**Submission on Northside Private Hospital, West Gosford Application No SSD-10159**

This submission is presented on behalf of Friends of Gosford Pty Ltd. We thank you for the opportunity to present a submission on the Northside Private Hospital, West Gosford Application No SSD-10159. In respect to this application we wish to make the following comments.

Friends of Gosford Pty Limited

Figure 57: AM Peak Period Distribution – Inbound Vehicles Per Hour (Traffix, 2019)

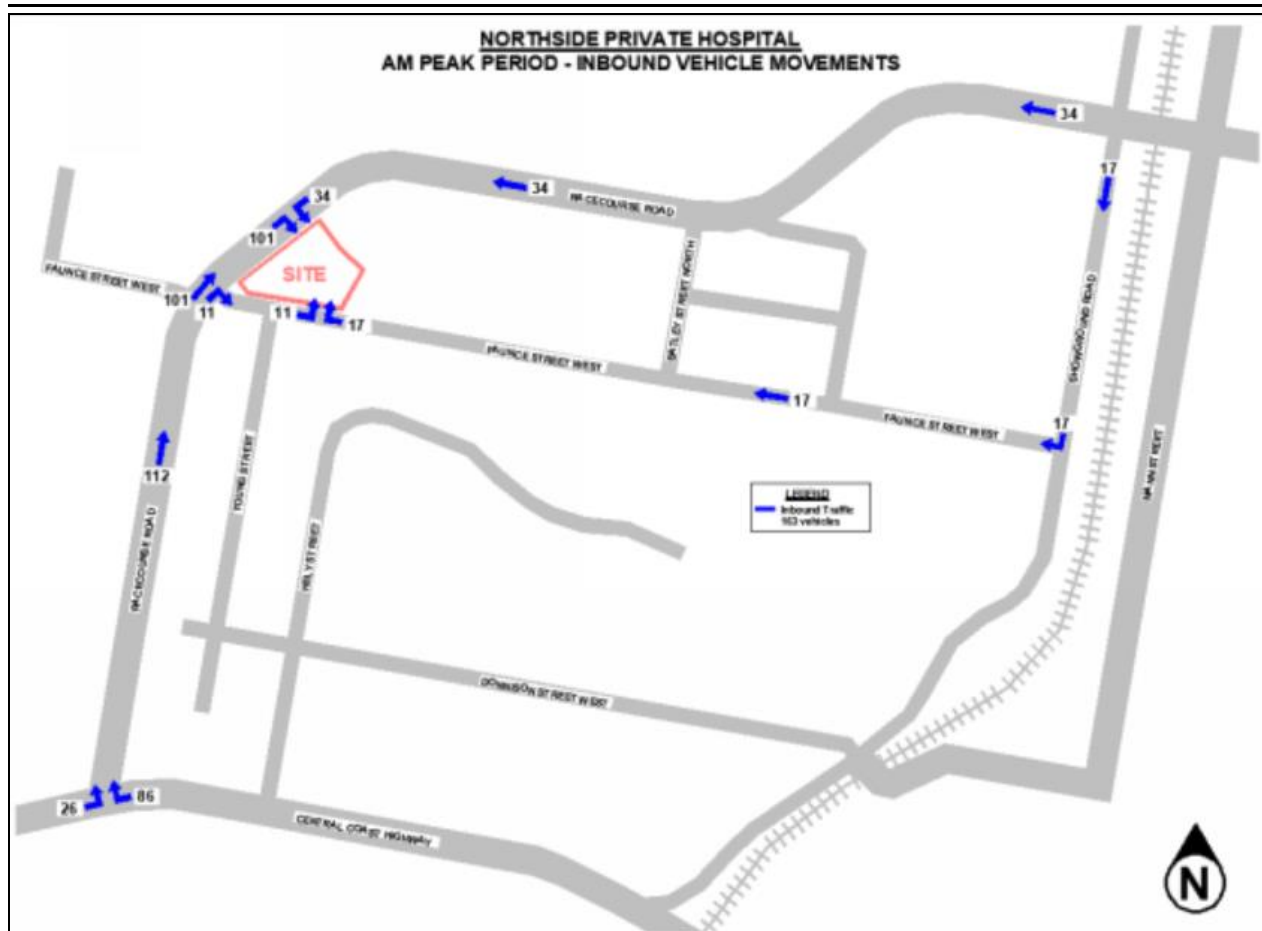
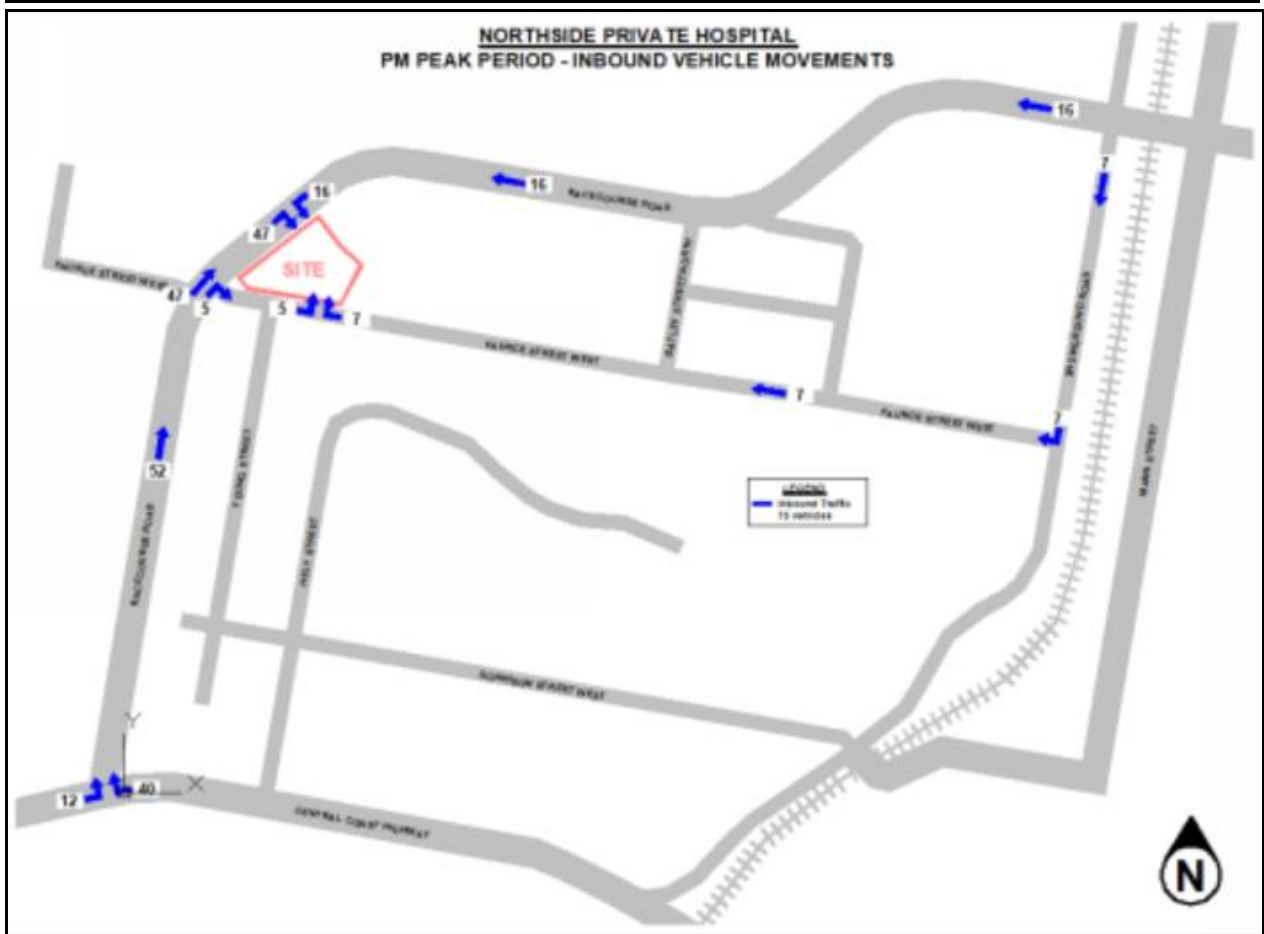
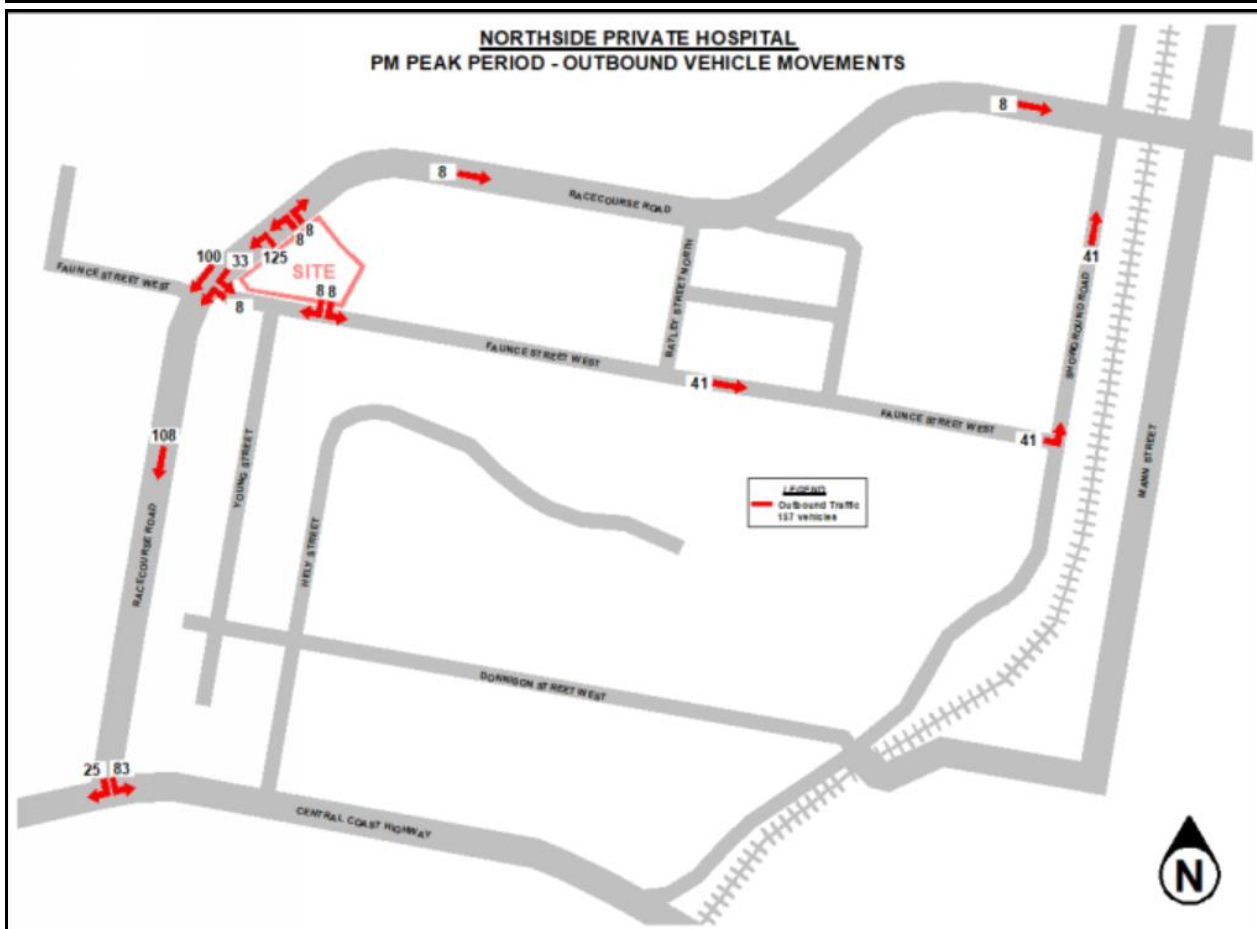
The first implication is the number of traffic generating activities impacting traffic along Racecourse Road and the railway bridge at Etna Street. We believe the traffic report has a significant oversight in that it only identified three (3) key intersections of the Central Coast Highway with Racecourse Road,

Racecourse Road with Faunce Street West and Faunce Street West with Showground Road. In our opinion the most significant intersections with traffic implications are the intersection of Racecourse Road with Showground Road, Etna Street Railway Bridge and the intersection of Mann Street with Etna Street which are illustrated in the accompanying aerial photo.

Personal experience of attempting to travel along Racecourse Road from the Central Coast Highway to Etna Street railway bridge has resulted in extensive delays. Reviewing both the EIS and the Traffic Assessment Report these documents have not addressed the current traffic delays and the implications of the proposed private hospital.

If deferring the application, we suggest the Department of Planning request the applicant consider the implications on traffic movement along Racecourse Road and Etna Street. If the Department were to request clarification from the applicant on this oversight, we would request that the applicant be requested to consider the traffic implications if the State Government were to consider an alternative east west/north south road bypass around the Gosford City Centre.
